CITY OF ALBUQUERQUE

June 16, 2015

**RE: Freddy's (Formerly "Whataburger"), 111 Coors Blvd. NW
Grading and Drainage Plan
Engineer's Stamp Date 6-03-2015 (File: K10-D001B)**

GRADING AND DRAINAGE PLAN

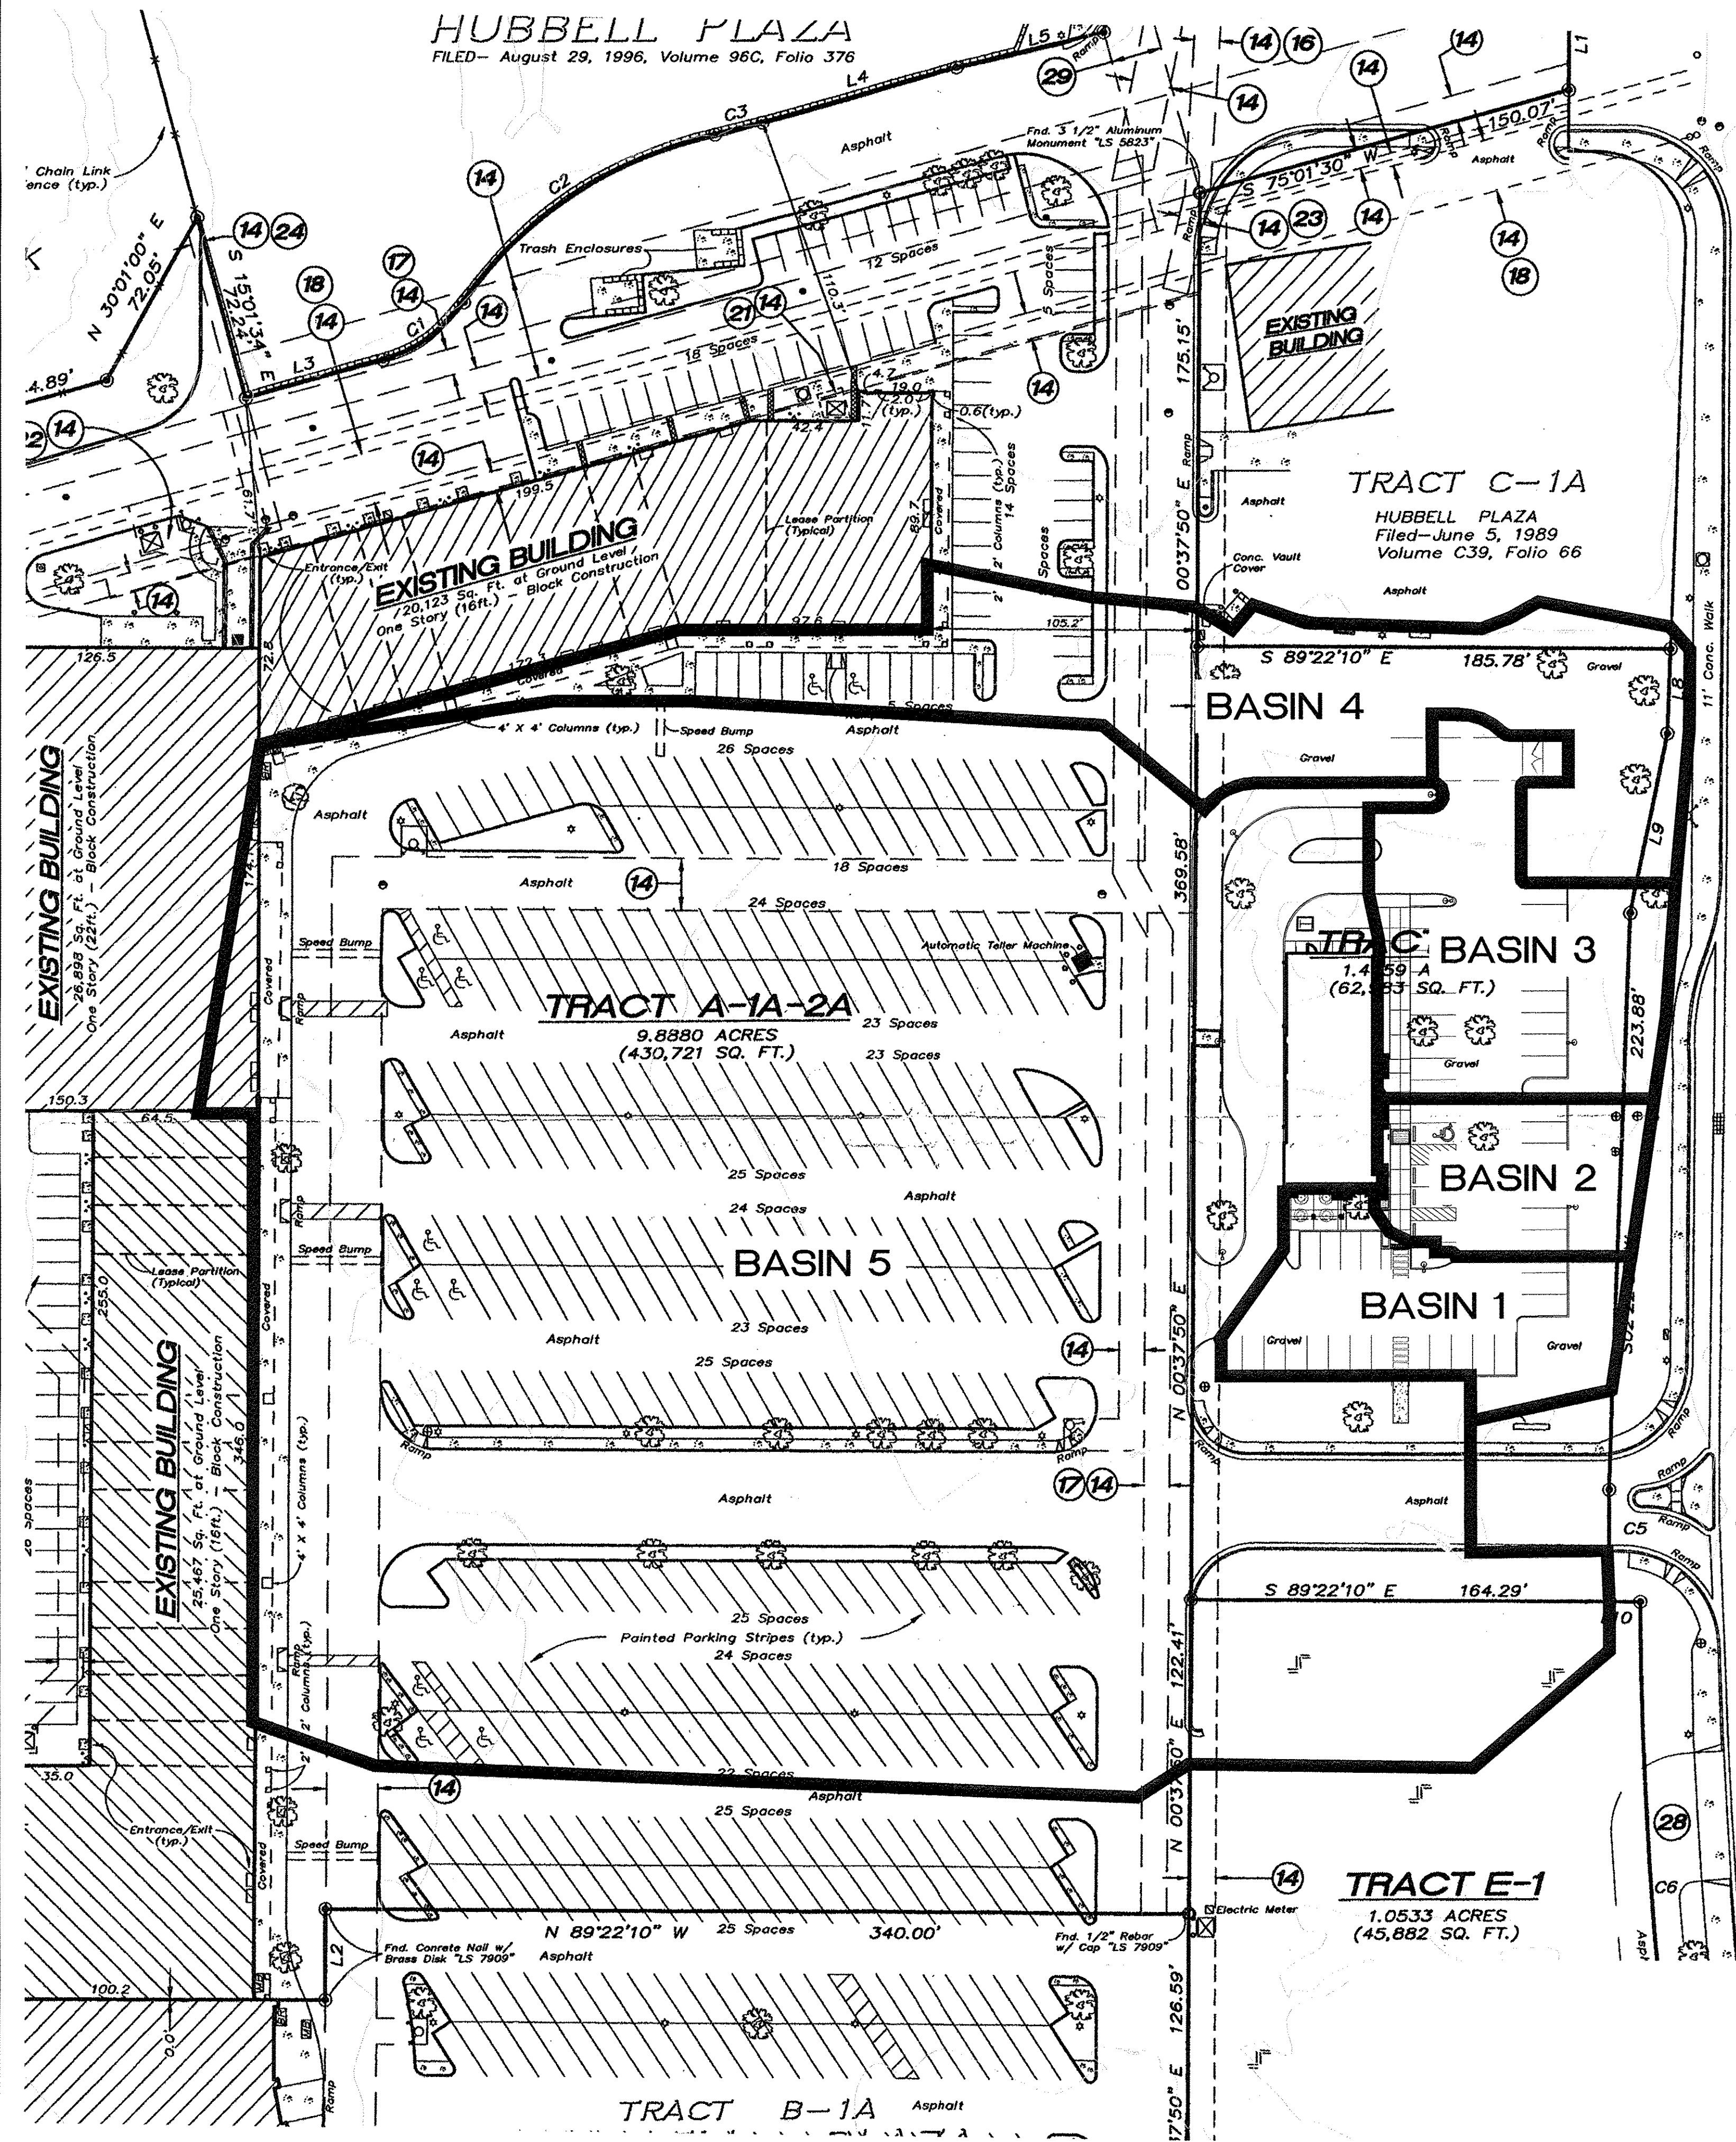
- 1) A new grading and drainage plan must be submitted based on the updated site plan which addresses EPC Comments. Ensure that the new site layout incorporates the same detention pond sizing as the old site layout.
- 2) The electronic submittal (Engineer's stamp date - 6/03/15) does not match the hard copy submittal (Engineer's stamp date - 5/18/15). The 6/03/15 plan addresses the latest and greatest comments (e-mail dated 6/01/15) that ask for additional existing spot elevations at the accessways from the shopping center parking lot and the grease trap for the trash dumpster.
